**To:** Michael Charek **From:** Mike Nugent  
**Fax:** 761-7260 **Date:** September 24, 2002  
**Phone:** **Pages:** 1  
**Re:** Radcliffe Glenn (153 A025)

Preliminary review has been done and I need the following information :

Radcliffe Glen Harvard Street, Portland, ME Larry Sturdivant 15 Garsoe Drive Portland, ME 04103	Michael R. Charek Architect 25 Hartley Street Portland, Maine 04103 (207) 761-0556	Structural Consultants: Swift Engineering 331 Main Street Norway, ME 04268 207-743-5885
	Sheet	ISSUED FOR PERMIT	S2

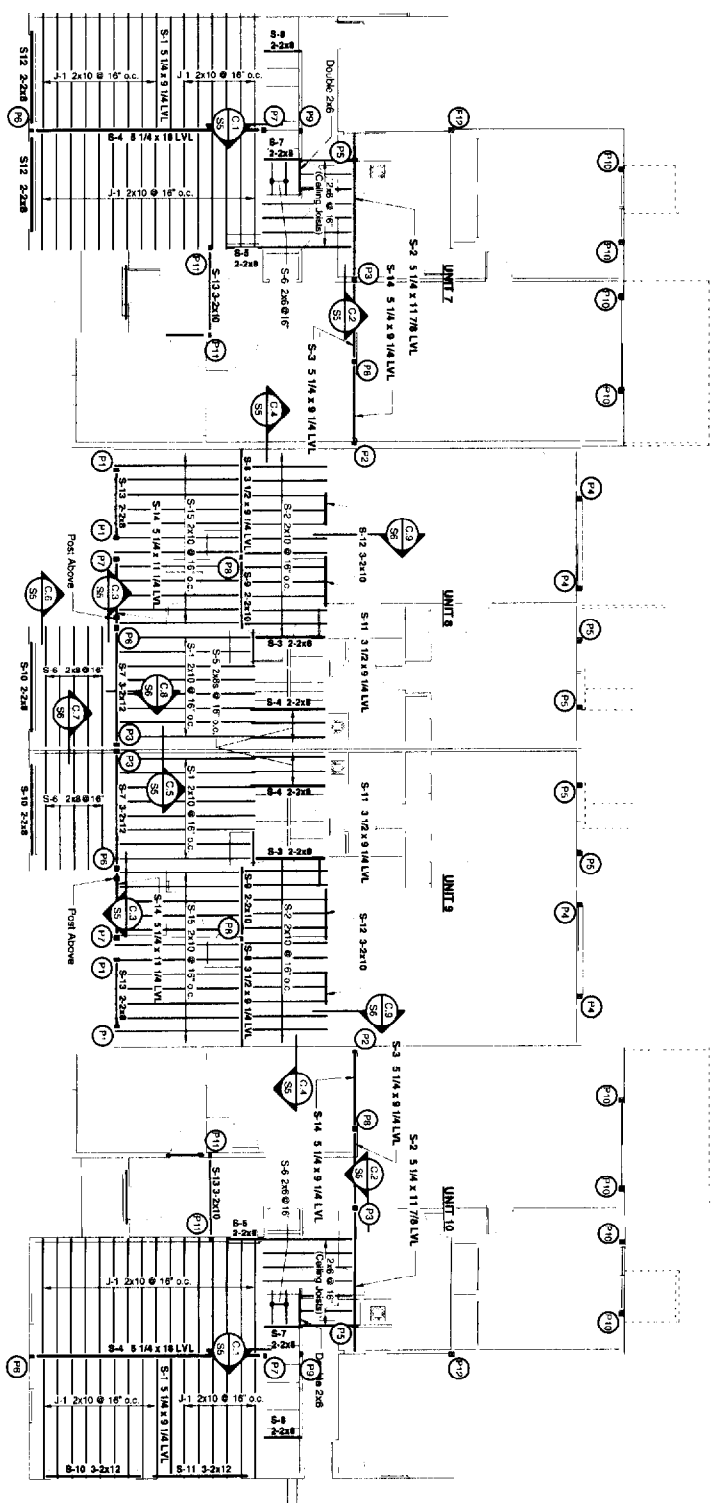
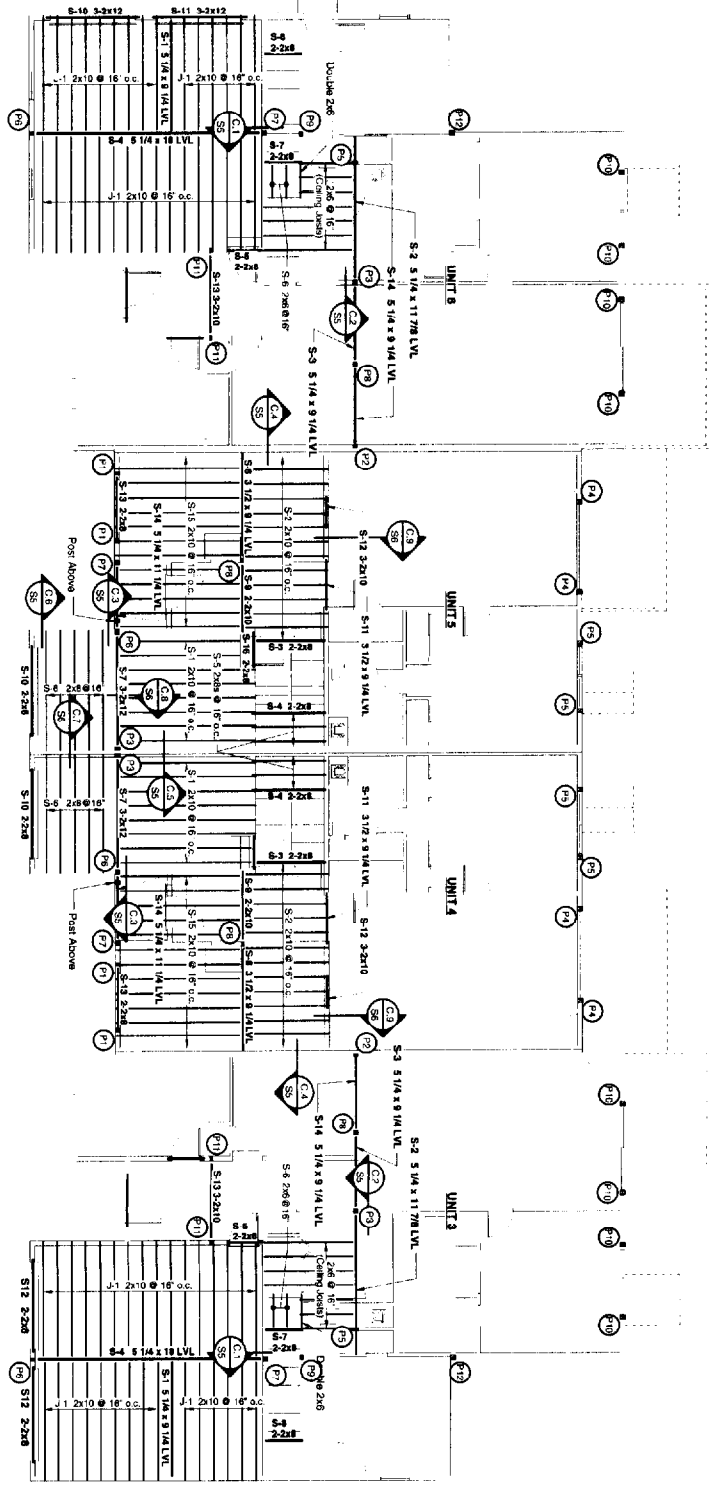
Let's discuss the type of lally column and spacing on page S2, it appears that the spacing is excessive based on girder span tables in the IRC.
